June 3, 2015

Re: Property of Capone-Newton  
368-374 Island Avenue, Peaks Island, Portland  
Tax Map 90-B-5 & 4

Drawing file: Ocean Street Status / PB 214-230 Nadeau Survey 3-20-14.pdf

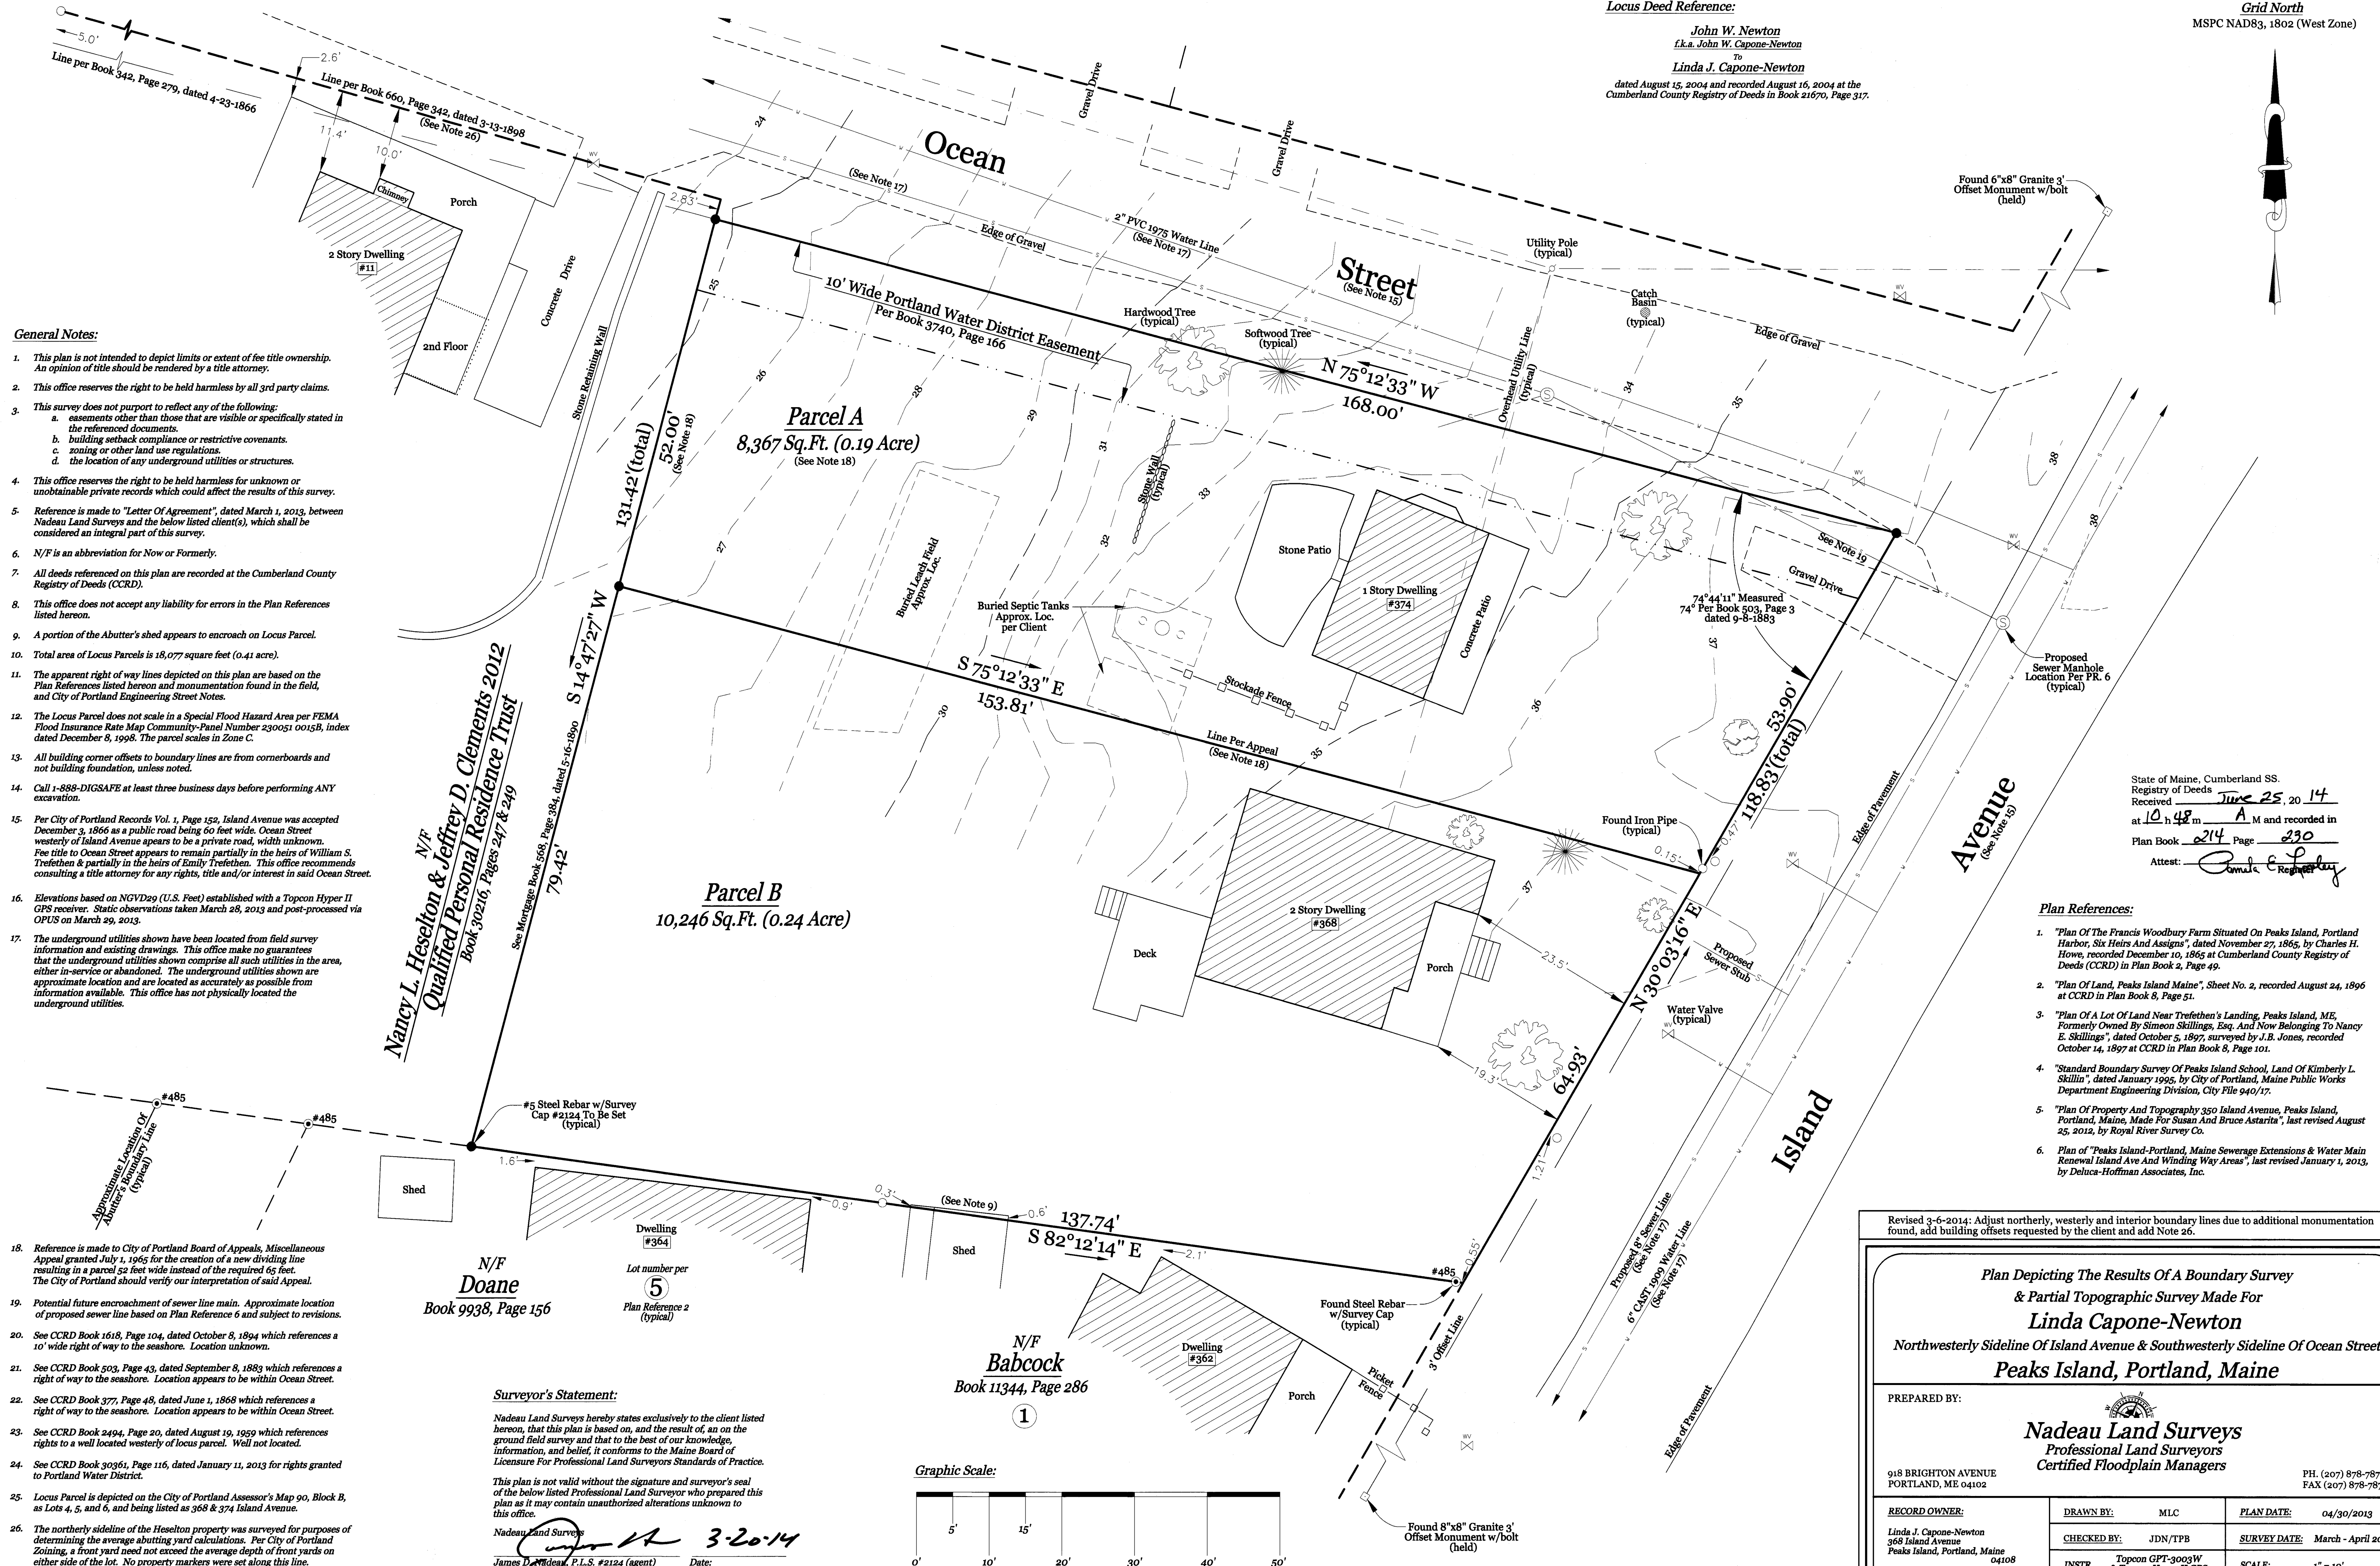
The access to the Capone-Newton under the proposed development is from “Ocean Street.” Ocean Street is shown on the survey done by James Nadeau.

As shown on the Nadeau survey, Ocean Street appears to have a scaled width of no more than 30.5 feet, at least 1.5 feet ***less than*** the minimum required for the 3 existing houses using it for access. There is no specific proposal from Newton-Capone regarding the development, so it is not certain how the “design” of the lot development will depict access. However, Ocean Street cannot be considered as the “front yard” if Ocean Street does not qualify as the applicable “street frontage.” If so, then for purposes of determining front, side and rear setbacks, I believe Island Avenue must be considered the front yard.

If, for some reason, the City determines that the front yard can be considered to be along Ocean Street, then Ocean Street must be improved to municipal standards to qualify as street frontage and access, as set forth in the Ordinance sections above. Under the Ordinance, there must be at least 70 feet of improved frontage along Ocean Street. Moreover, under the Site Plan

standards, it is my understanding that the entire length of an unimproved street needs to be constructed to applicable standards when “development” is being undertaken. In this case, that would be over 160 of Ocean Street extending from Island Avenue.
